2 No. detached houses with garages. This is a Departure from the Development Plan.
Land at West Drive Ham Manor Estate Angmering

Thank you for your internet representation made on 25th March 2015 which has been recorded as '**an objection**' with the comments as follows:

Plot 1 Front Elevation (North)

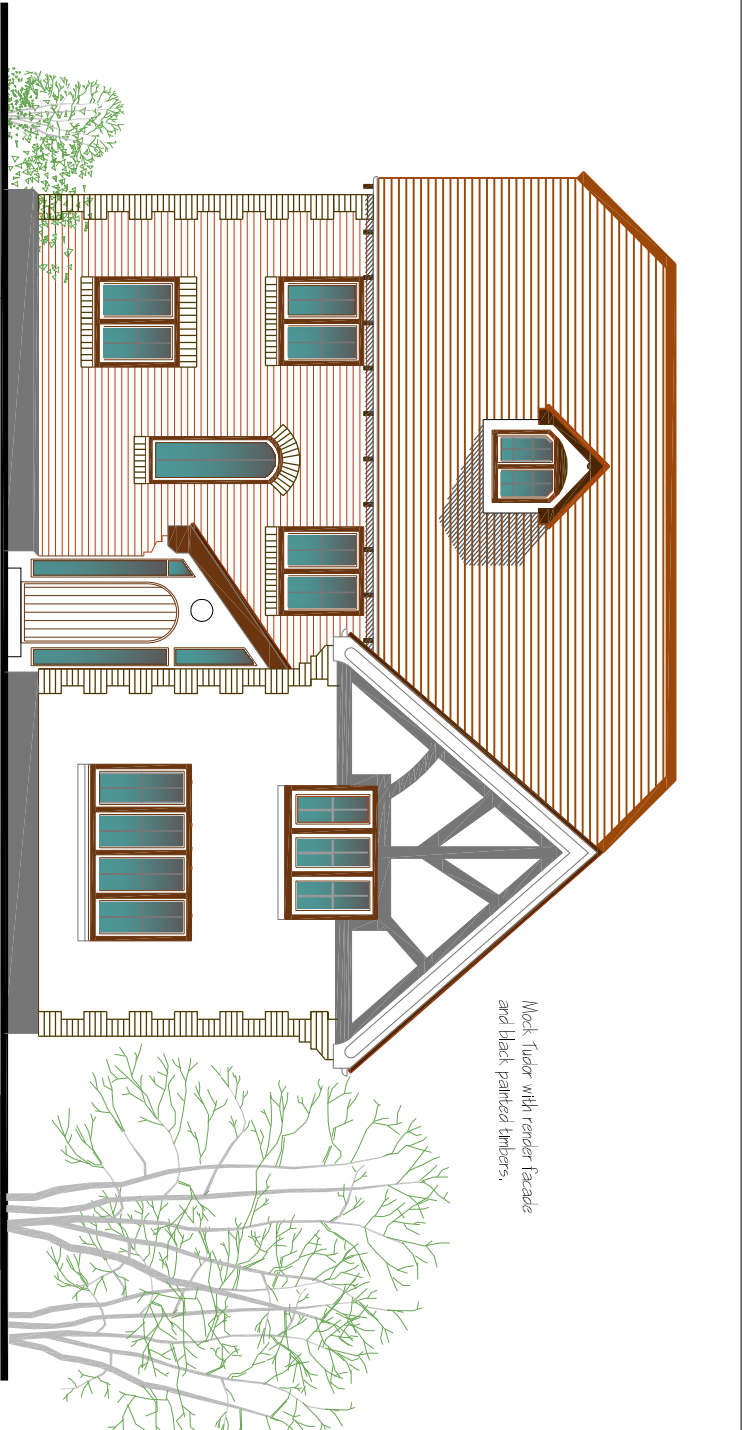
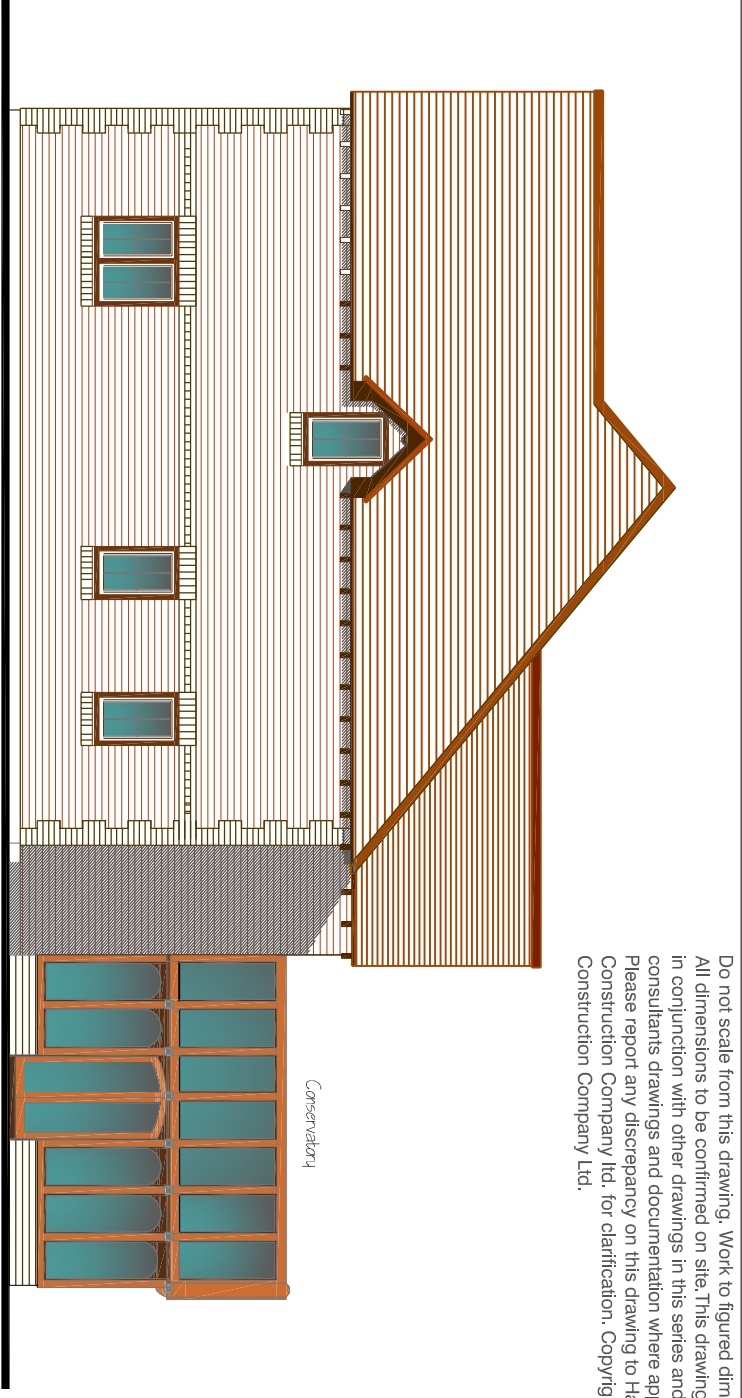
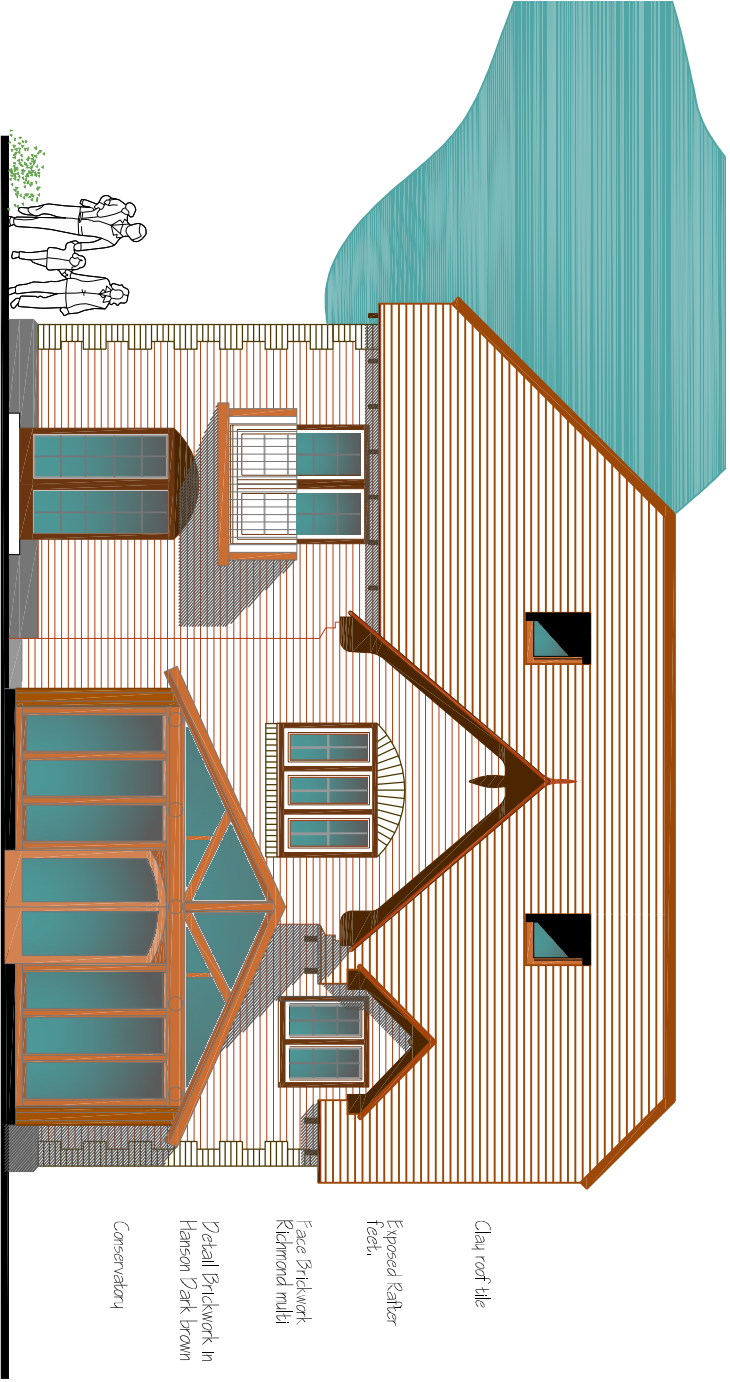
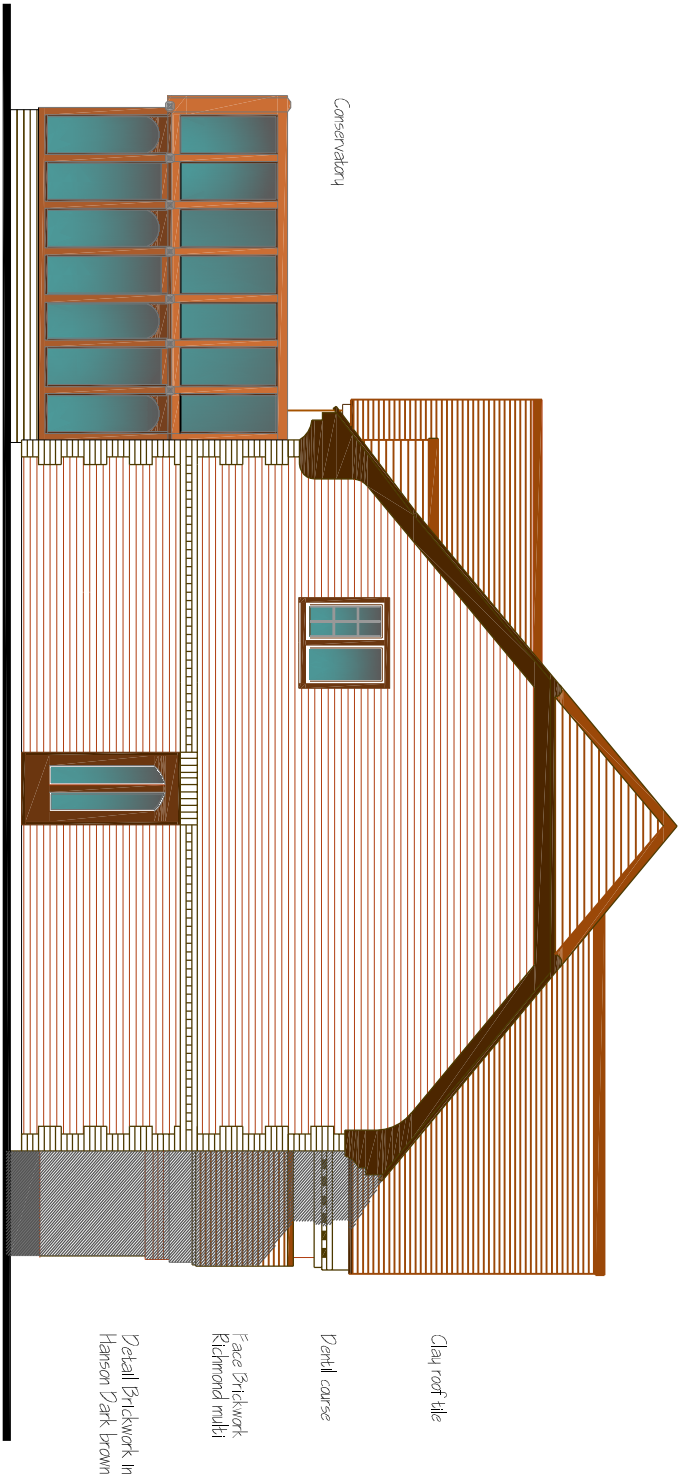
The application is for the erection of two dwellings on a site for which permission was previously granted under reference A/190/06. While the number of dwellings remains at two with substantially the same 'foot print', the design has altered boasting a more prominent roofline profile; and, the use of the roof area as habitable space with the addition of dormer windows, presenting in effect 2 1/2 storey buildings.

In our view the design as revised from that subject to the 2006 approval, is out of keeping with the neighbourhood area, where houses are exclusively of two storeys. The erection of homes with additional living space in the roofs, effectively 2 1/2 storeys, with attendant impact on our own property, would be unacceptable and inappropriate.

Front Elevation (North) Plot 2

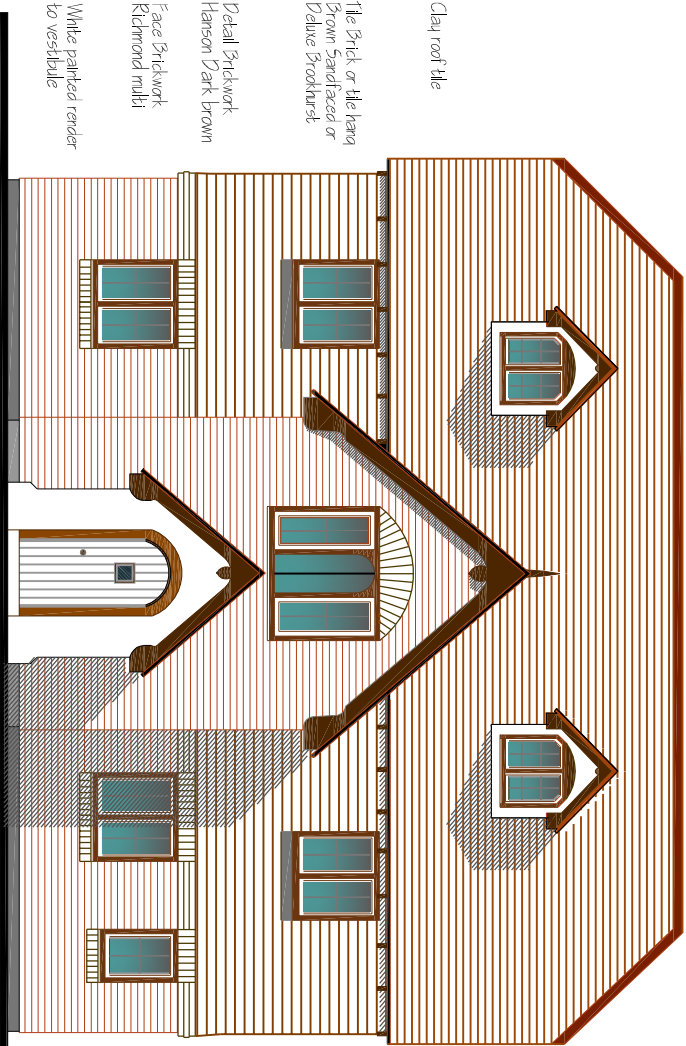
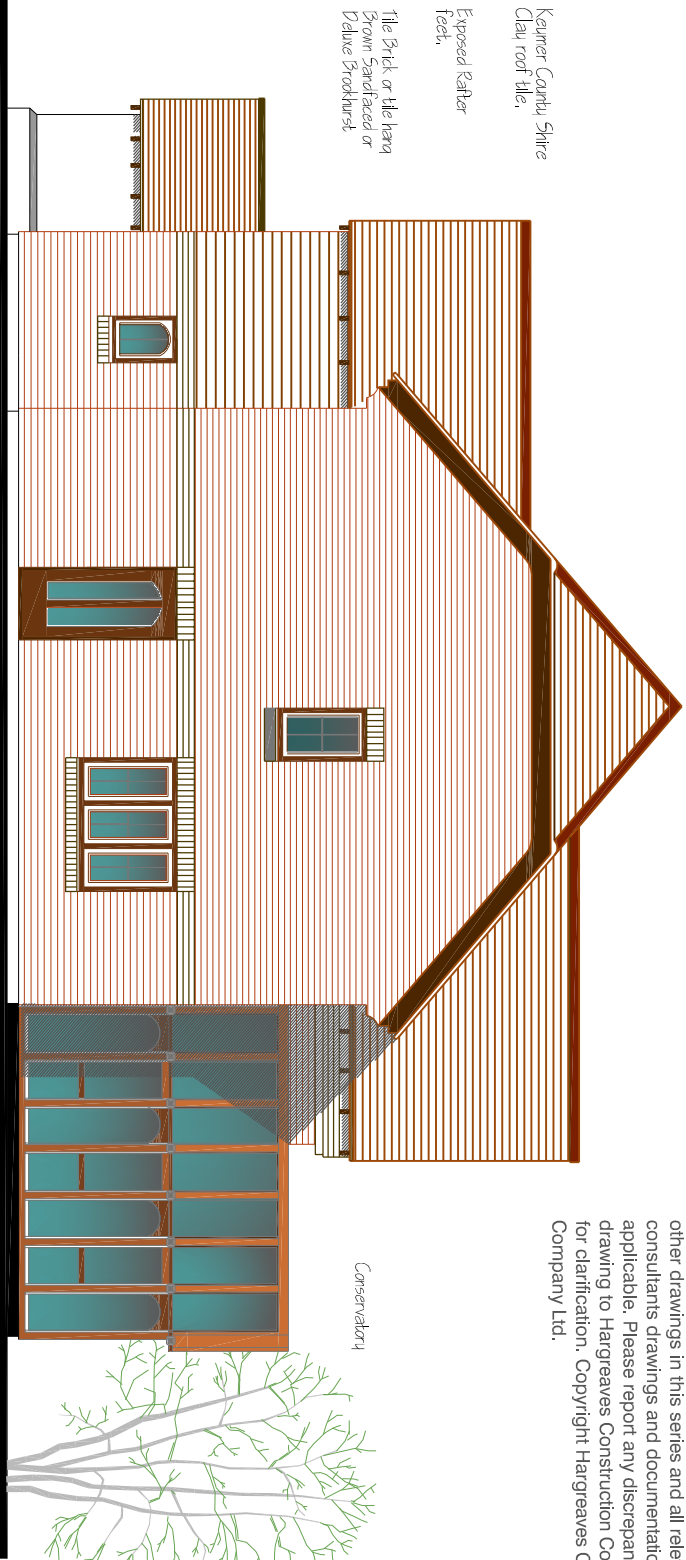
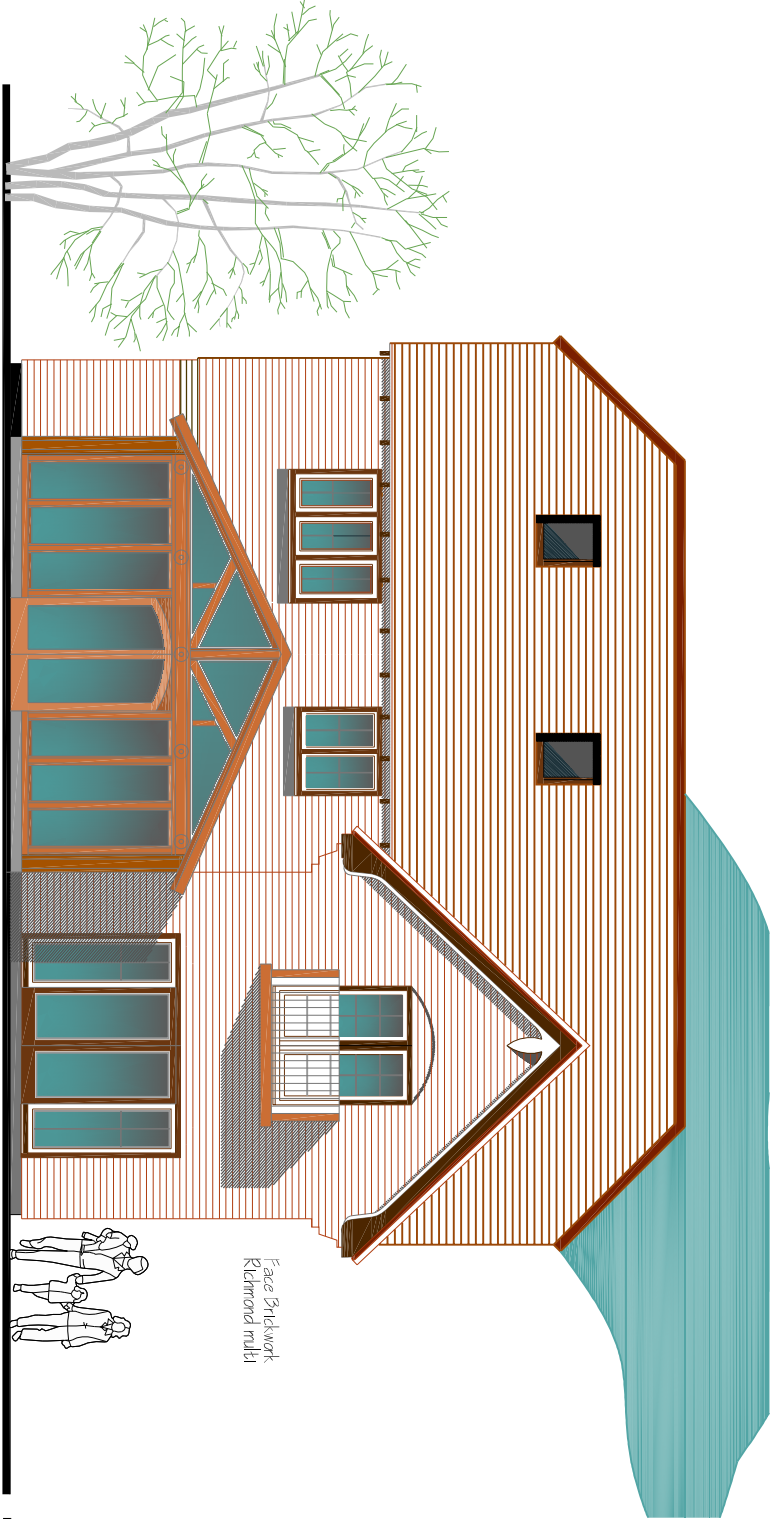
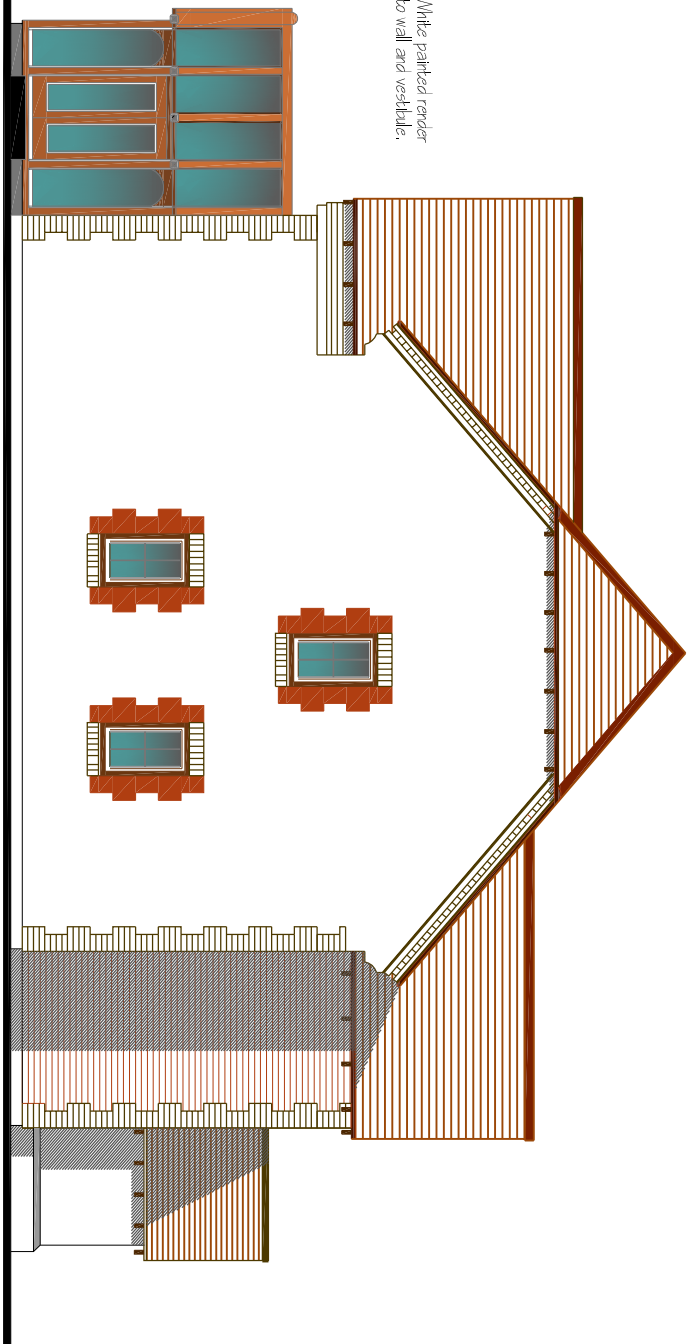
As presented on the application plans, the houses have a north/south aspect, with both of them, but particularly Plot 2, facing directly on to our own property. The combination of the plot elevation with the overall height of the houses will result in the roof dormers overlooking our home and depriving us of reasonable privacy in our upper storey bedrooms. In addition, the combination of proposed roof design/height and the elevation of the site will serve to have an overpowering effect on the adjacent properties particularly those situate on the eastern edge of West Drive.
